RE: **Albuquerque School of Excellence
6316 Tesuque NW
Grading and Drainage Plan
Engineers Stamp Date 5/15/2020 (E10D077)**

Based upon the information provided in your submittal received 5/18/2020, this plan is approved for Grading.

C-1

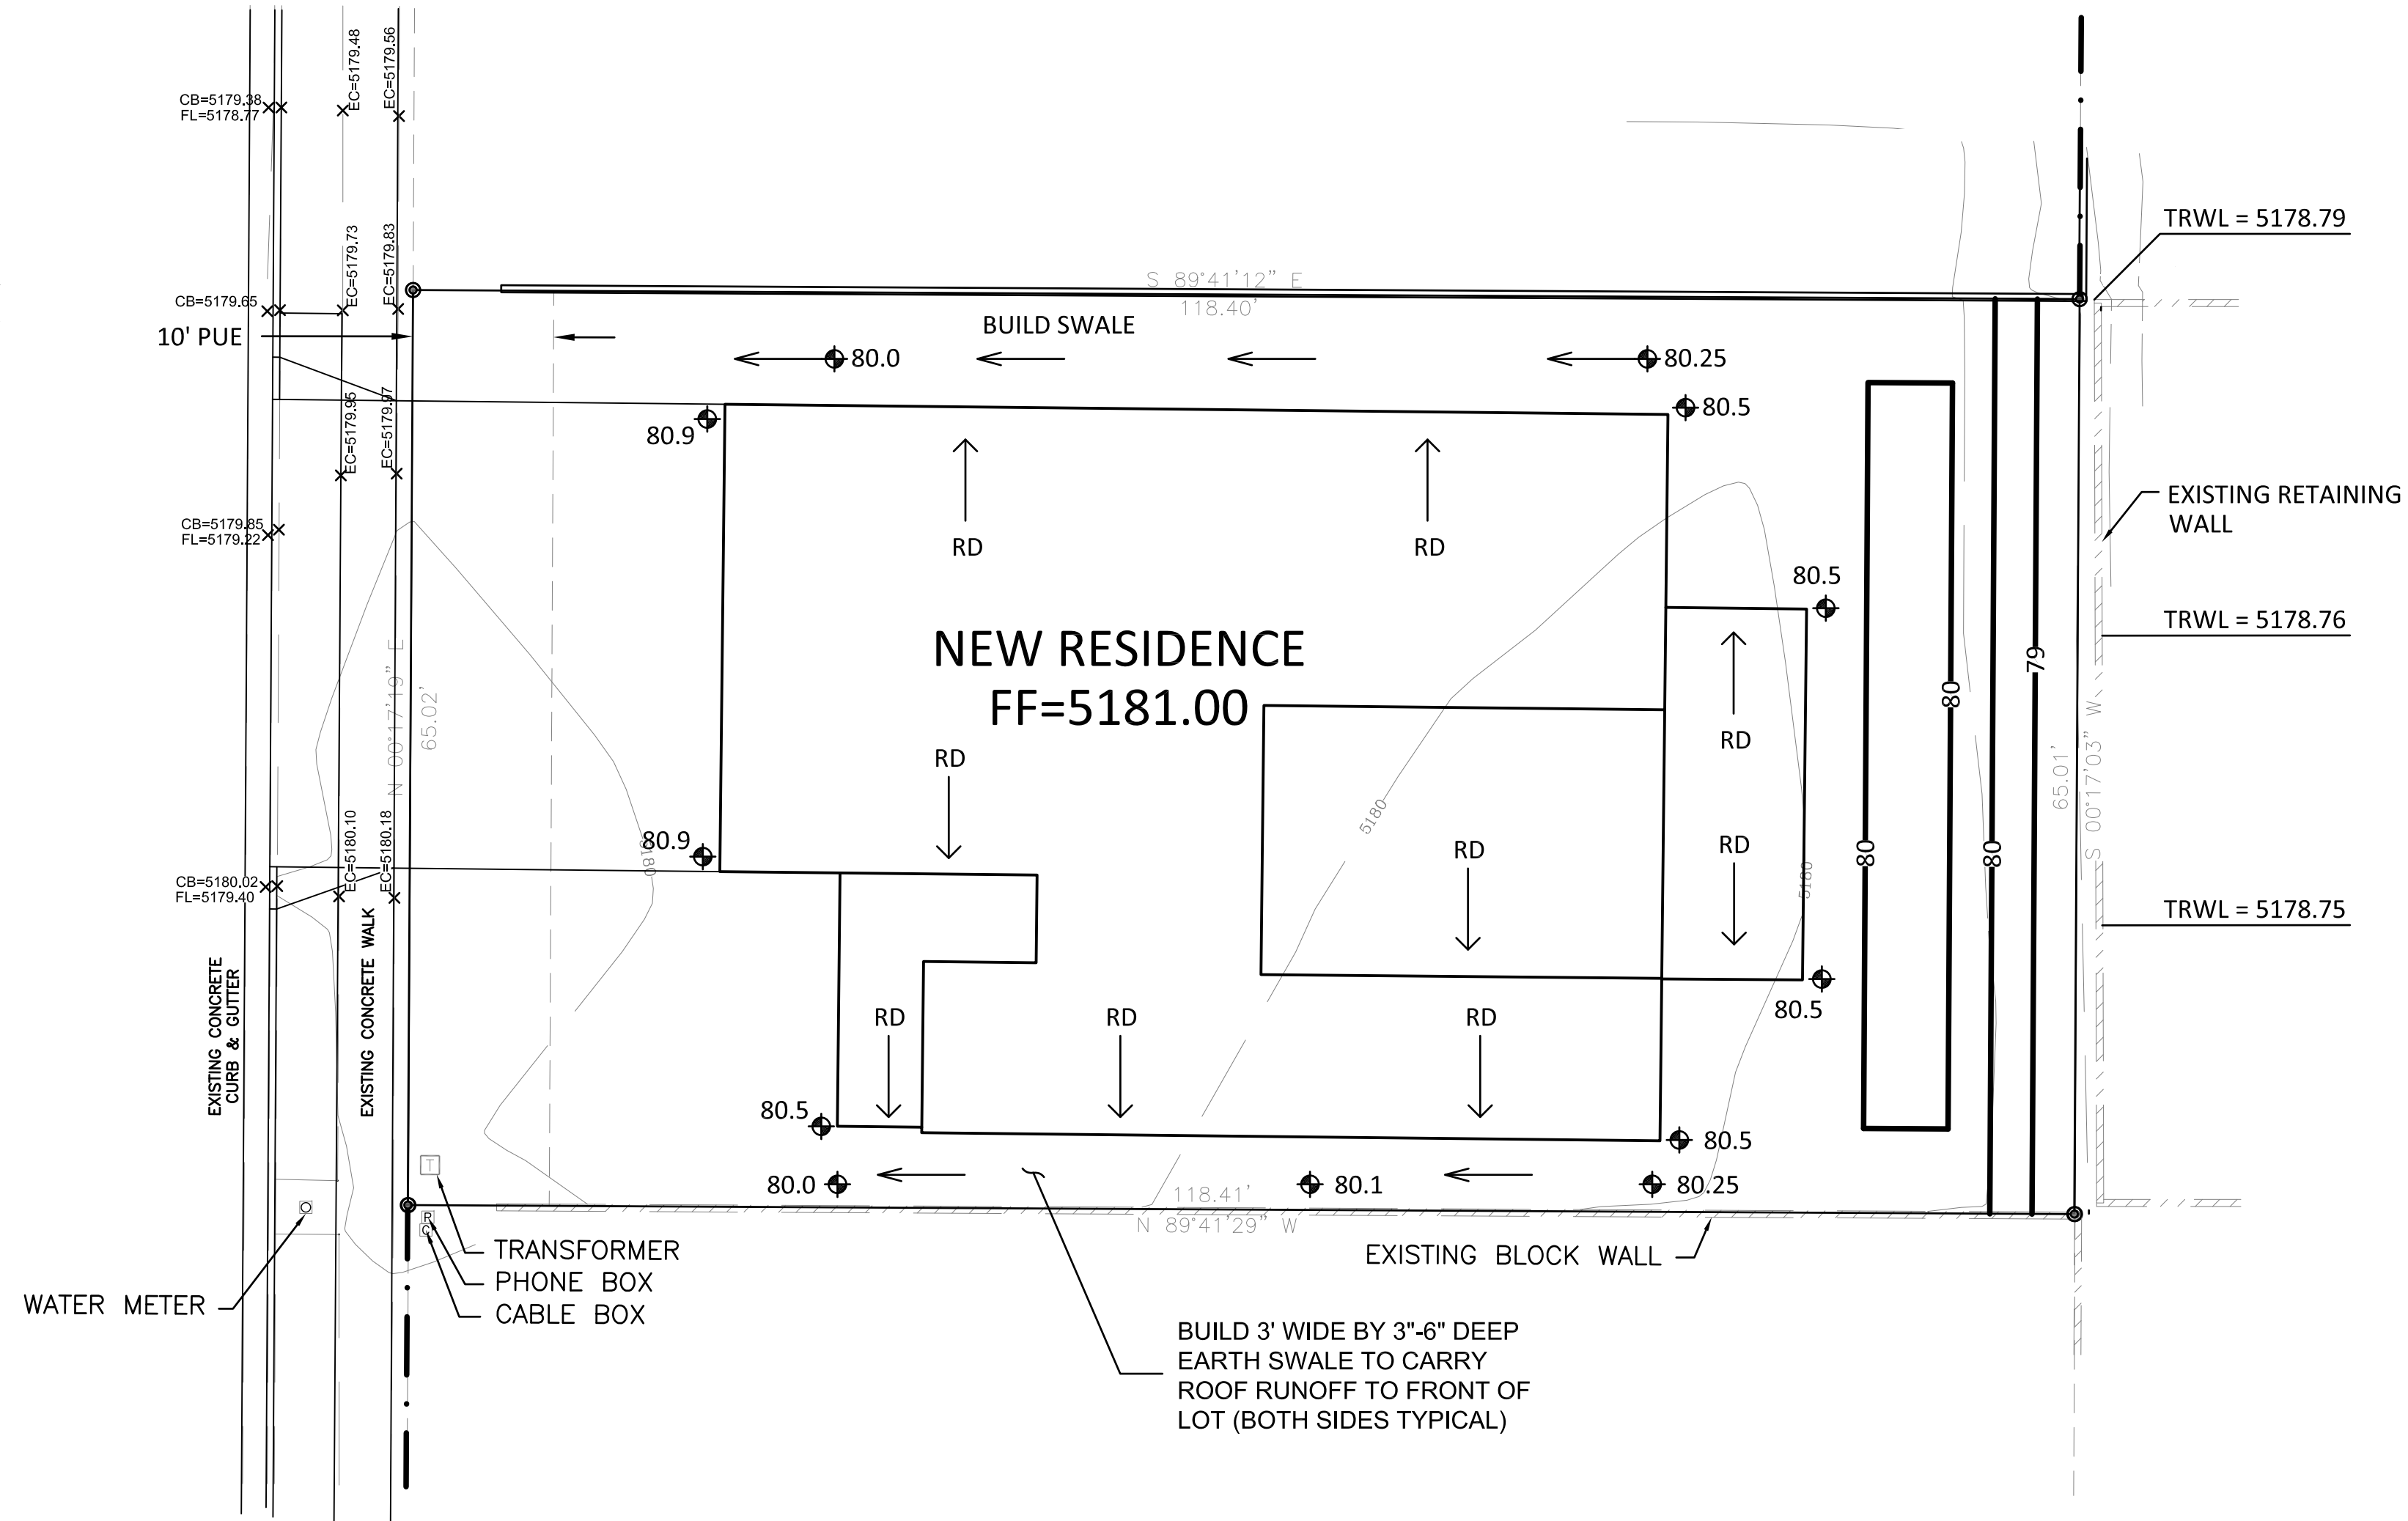
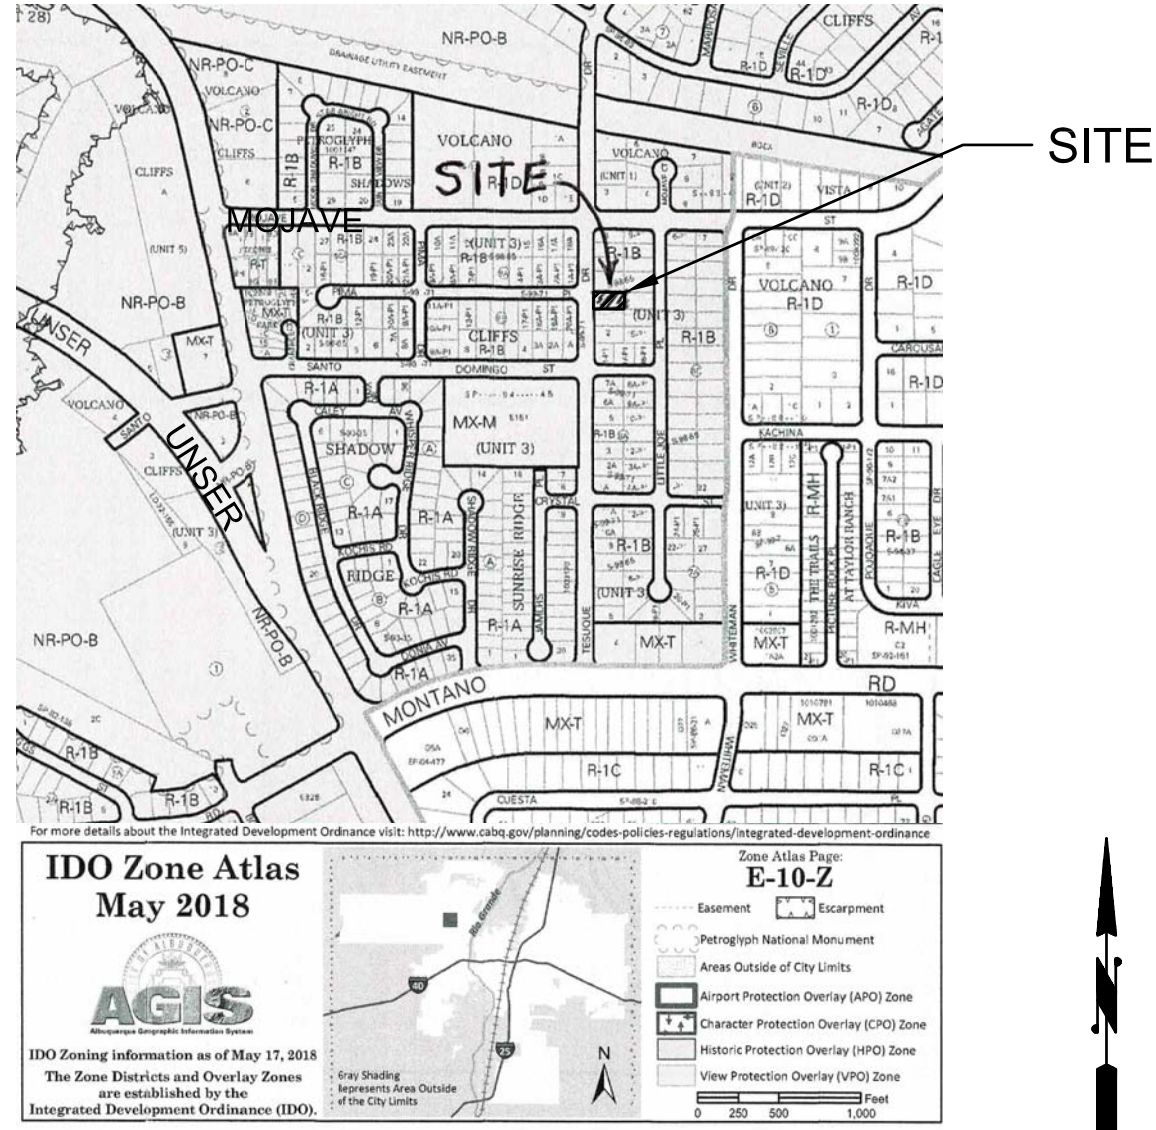
Prior to Building permit approval a Pad Certification will be required, provided by the Engineer or a registered Land Surveyor.

Advise the owner contractor not to use dirt as a ramp to climb the curb, use lumber or crusher fines for this purpose.

Reiterate to the Owner/Contractor that a separate permit for a garden/retaining wall must be obtained with the approved G&D plan and Pad Certification. Also, if a swimming pool is to be placed the grading and drainage plan will change and will need to be resubmitted.
